Our Ref: EP/32/21/NMA

Non-material amendment following grant of EP/7/21/HH to increase the size of new window on first floor south elevation.

23 Little Dormers Upper Drive East Preston BN16 1QN

SOUTH ELEVATION

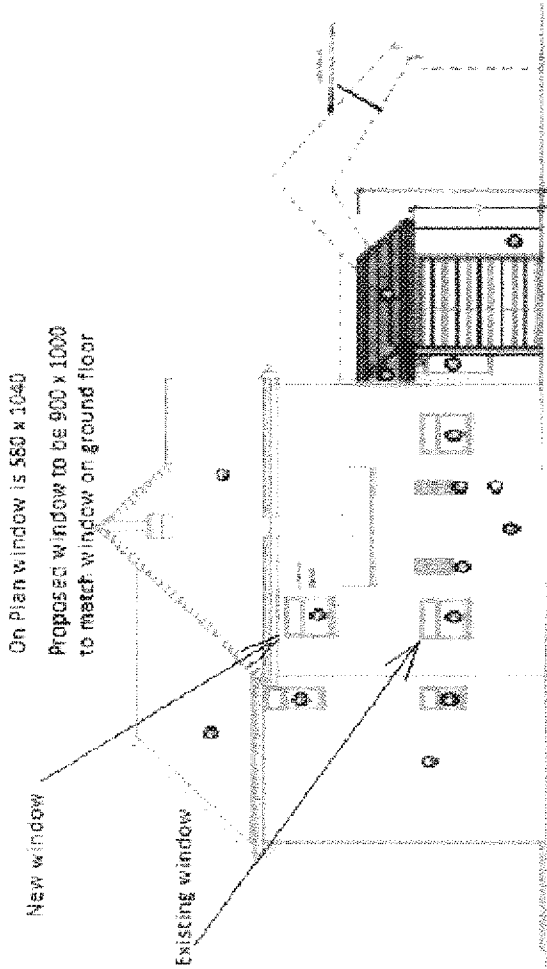
From the information submitted I am able to accept drawing no 'South Elevation (NTS)' as a Minor Amendment to EP/7/21/HH subject to the following planning condition.

The window on the first floor of the south elevation must be completely obscurely glazed. The window is to remain fixed shut below 1.7m. In order to protect the amenities of 21 Upper Drive to the south.
